Our Ref: EG/63/18/HH

**Town & Country Planning Act 1990 (as amended)
Town & country Planning (Development Management Procedure) (England) Order 2015
Application for Planning Permission for Works or Extension to a Dwelling**

Development 2no. front extensions, new roof to include accommodation at first floor level & internal alterations throughout.
Location 40 Elm Grove Barnham

**BLOCK PLAN**  
*Ordnance Survey (c) Crown Copyright 2018. All rights reserved. Licence number 100022432*  
1:500

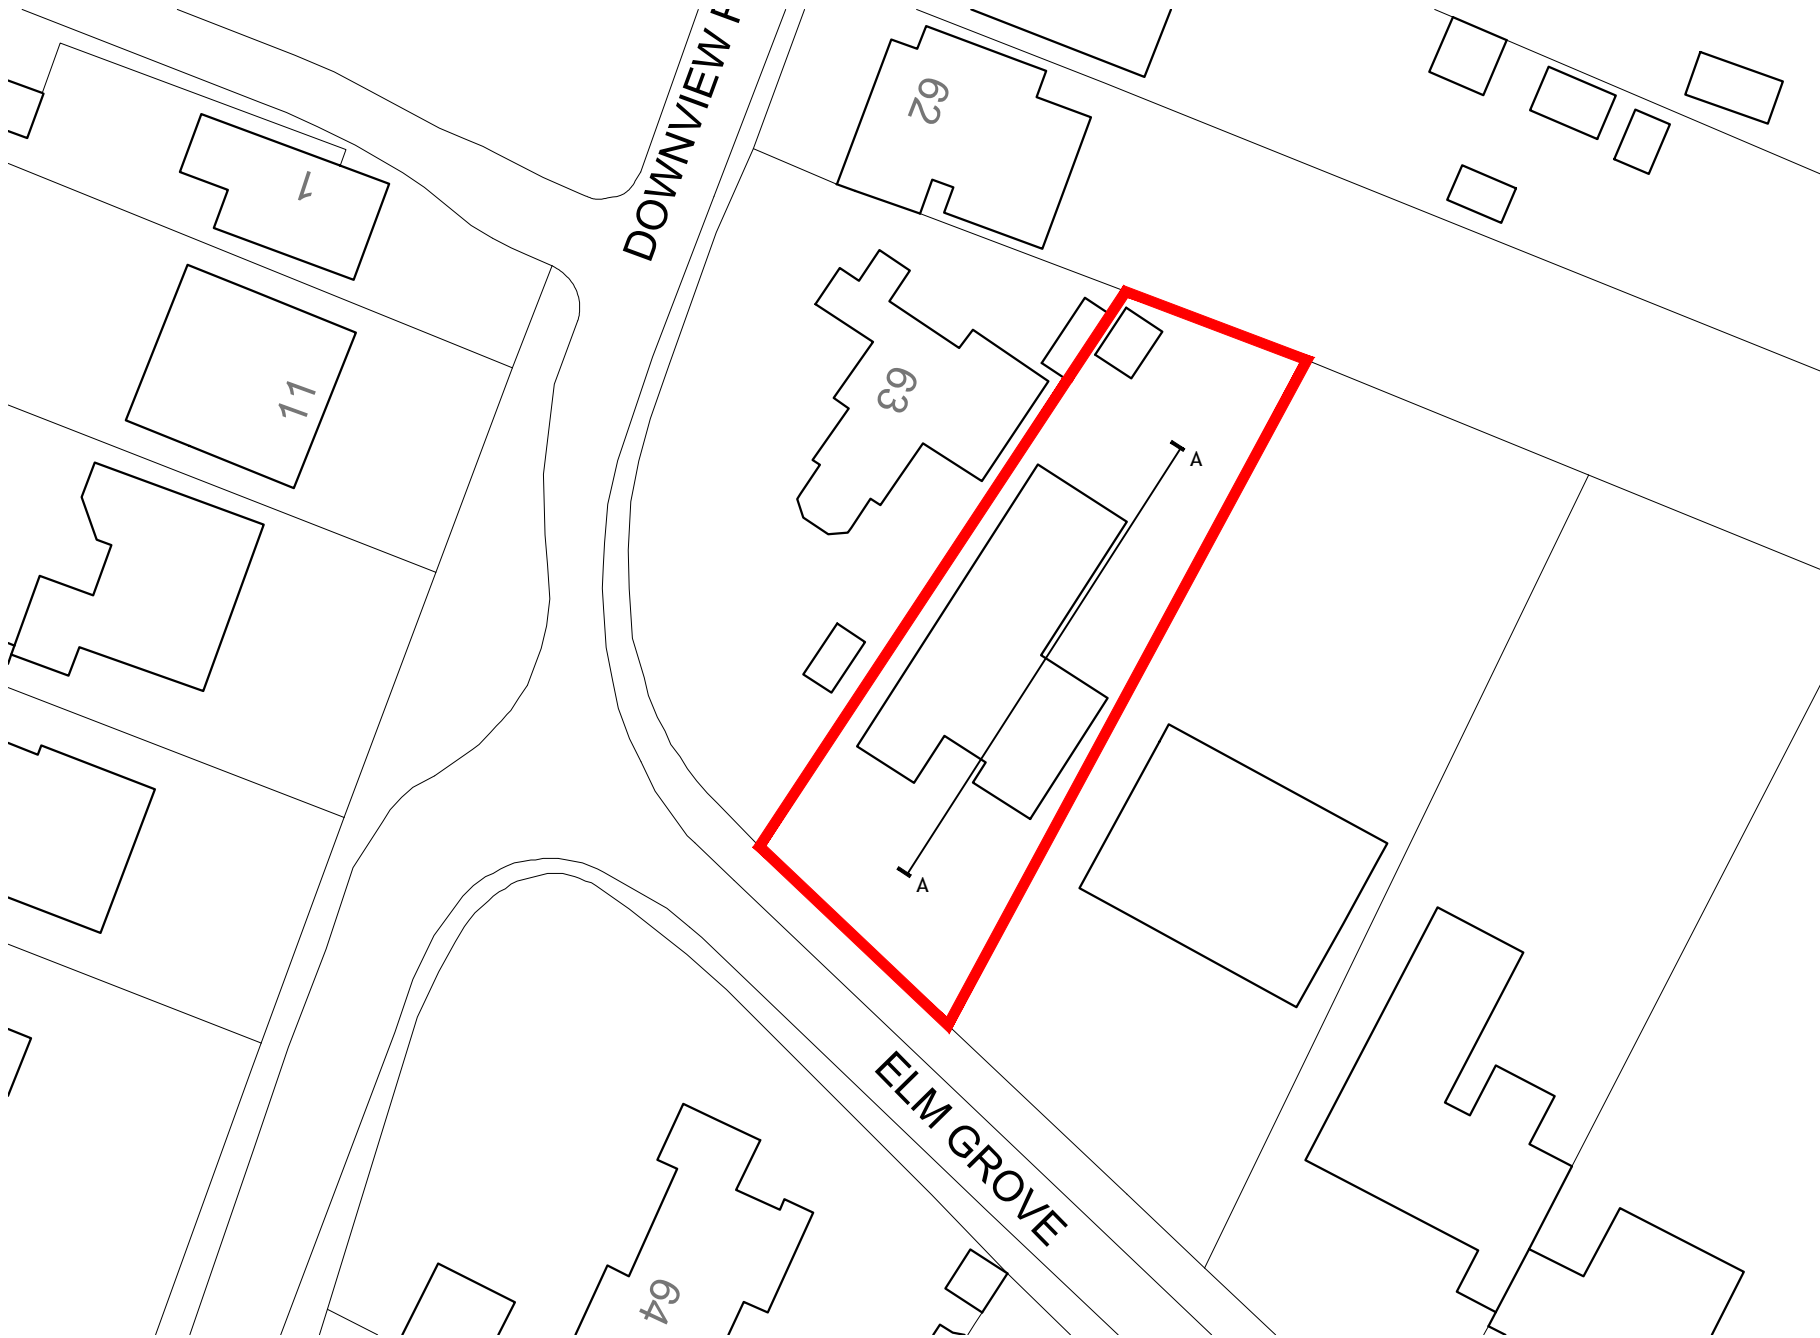
Block Plan

Please submit 1 electronic or 3 paper copies of an amended block/site plan at a scale of 1:500 or 1:200 showing the position of the proposal with measurements to the boundaries
